A38 JUNCTIONS SCHEME—LITTLE EATON JUNCTION.  
APPLICATION FOR DEVELOPMENT CONSENT ORDER.

UPDATED WRITTEN REPRESENTATIONS BY BREADSALL PARISH COUNCIL  
TO THE EXAMINING AUTHORITY

## **A38 DERBY JUNCTIONS DCO APPLICATION**

### **RESPONSE OF BREADSALL PARISH COUNCIL TO THE EXAMINING AUTHORITY'S SECOND WRITTEN QUESTIONS.**

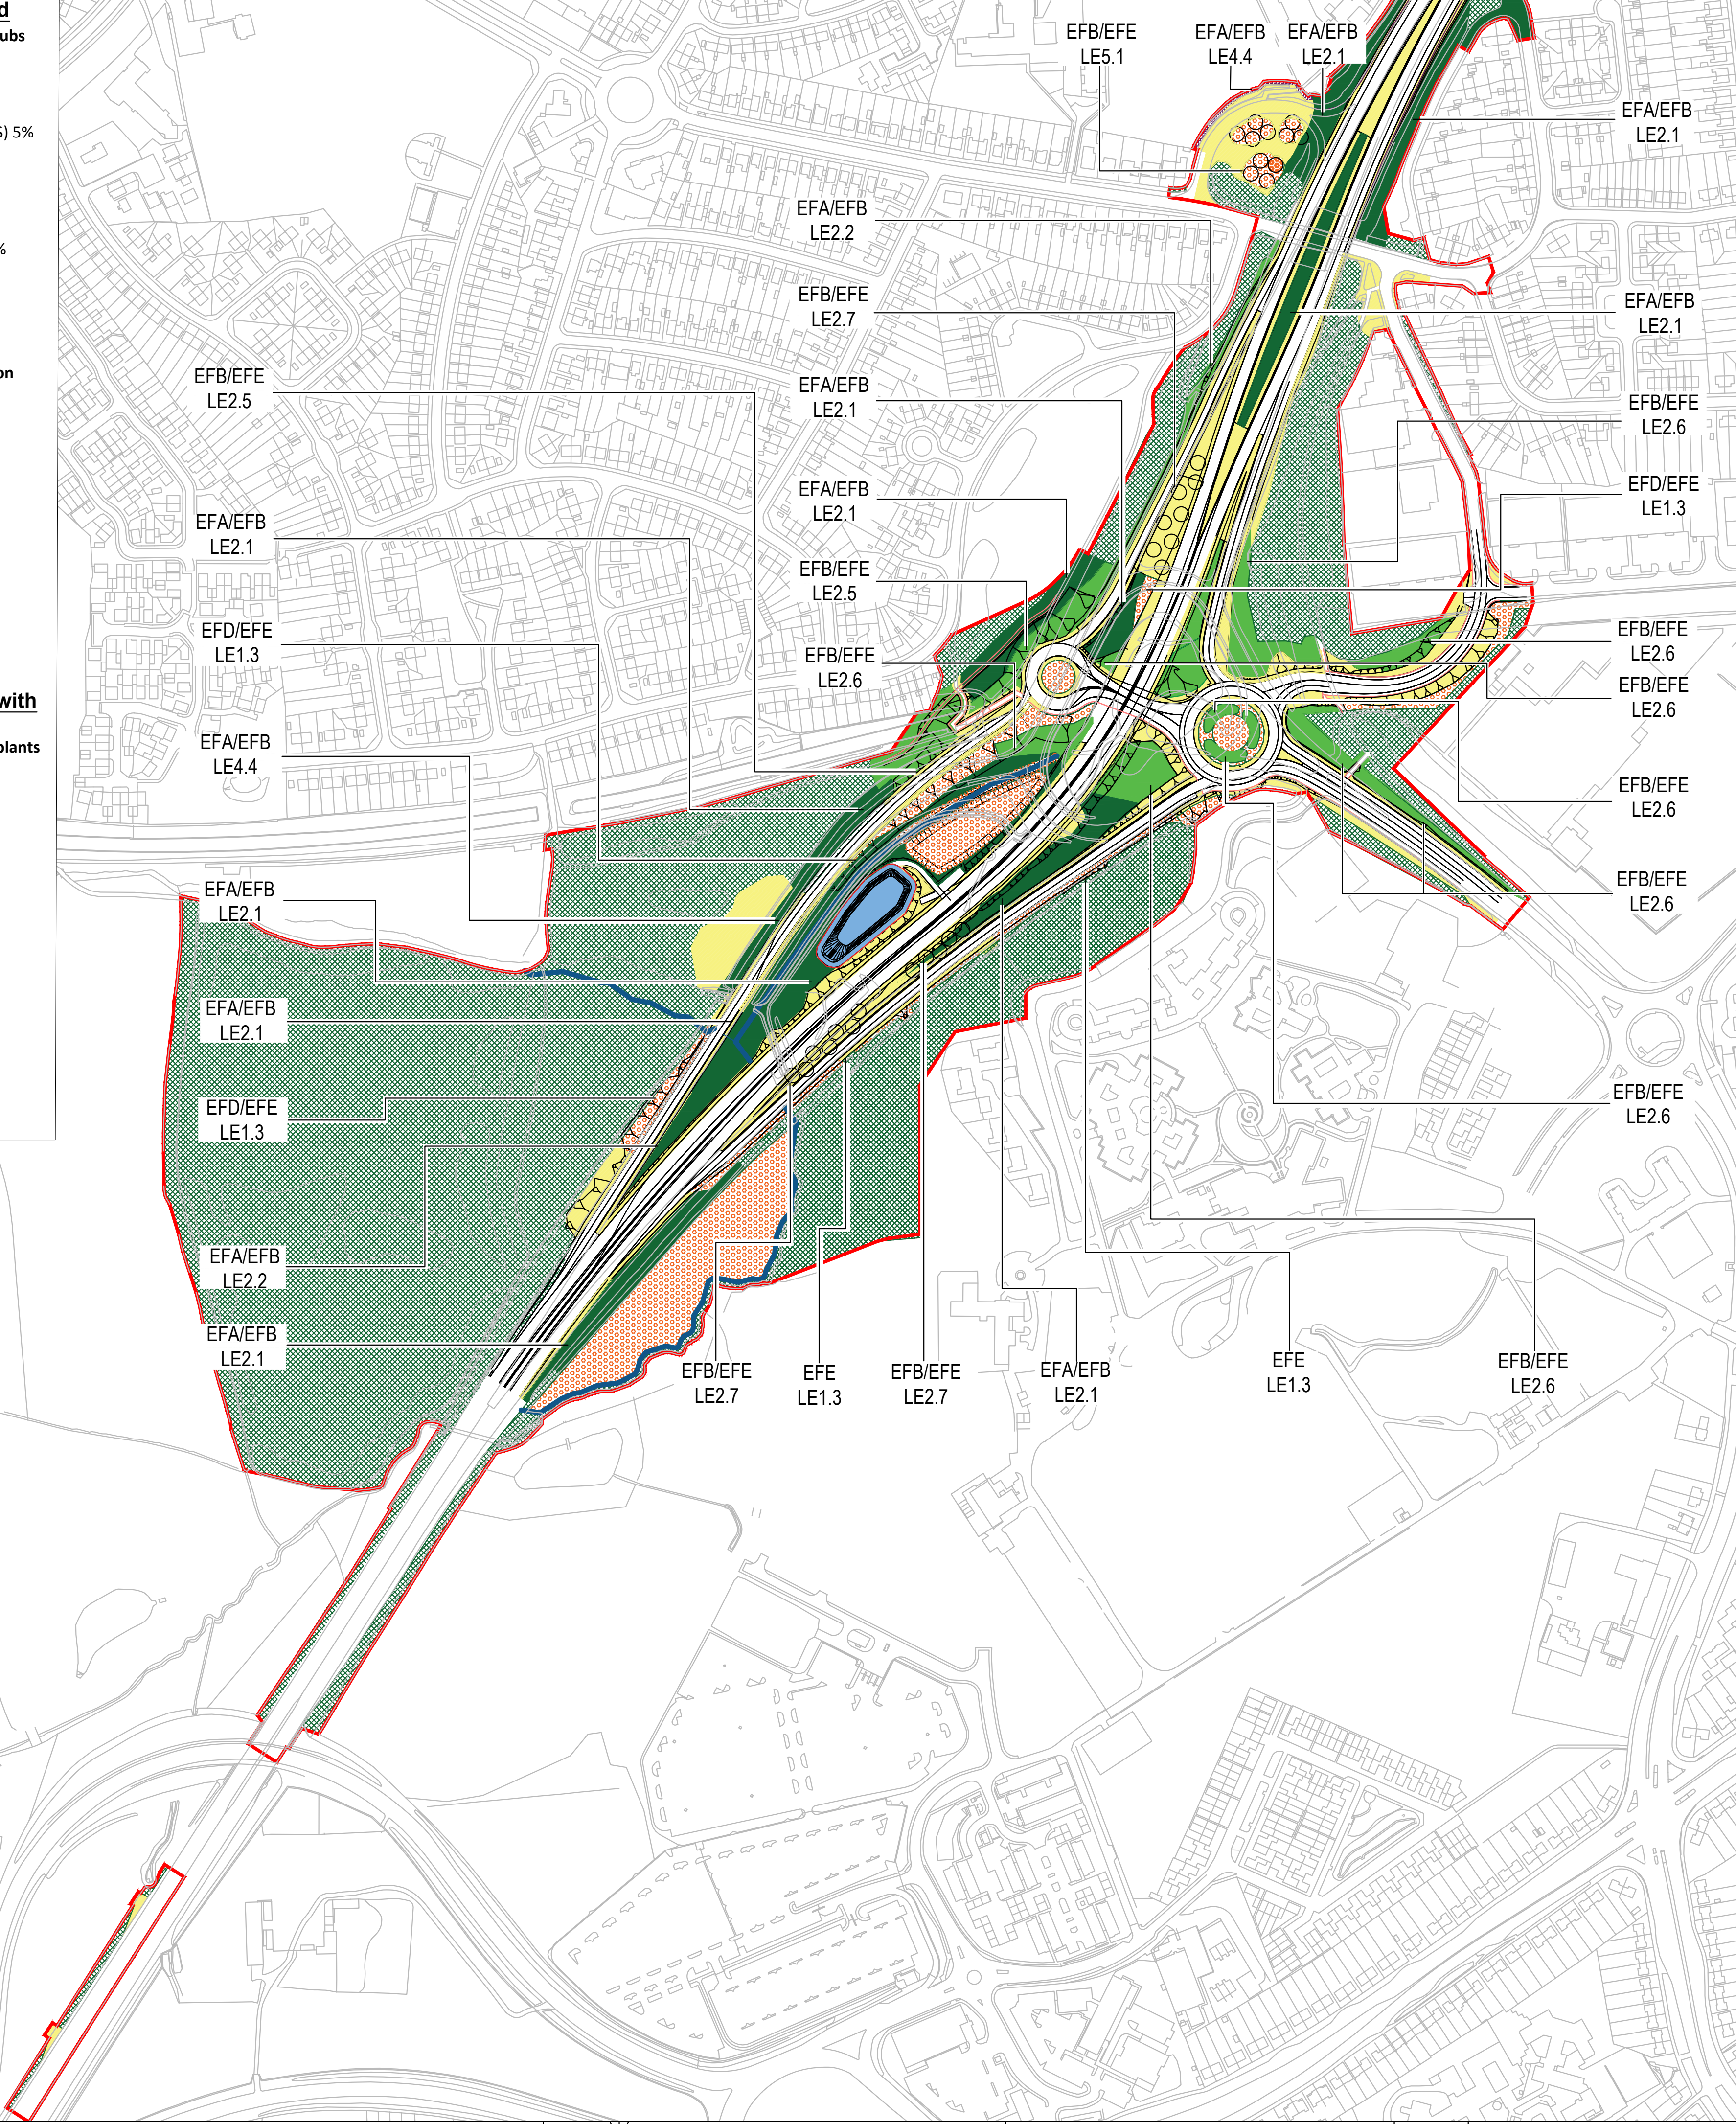
The Parish Council continues to be concerned that the tree belt alongside the southern end of the slip road and the roundabout is far too narrow in the present design to provide effective screening. The discussion at the hearing on December 11<sup>th</sup> showed that the tree belt at this location is far narrower than those elsewhere around the new junction despite the importance of this particular section in providing a screen between Breadsall and the new road. The Parish Council believes that this provides ample justification for increasing the permanent land take if that is necessary. It is understood that Highways England will in the first instance examine options for moving the ponds eastward to create more space for the tree belt and will liaise with the Parish Council.

Highways England state that the current composition of the tree belts is based on ecological considerations and includes just 10% evergreen species. In this particular location, however, the tree belt has an equally important function in helping to screen Breadsall from the physical effects of the new road. The Parish Council concludes that a much higher proportion of evergreens is needed to provide year- round screening.
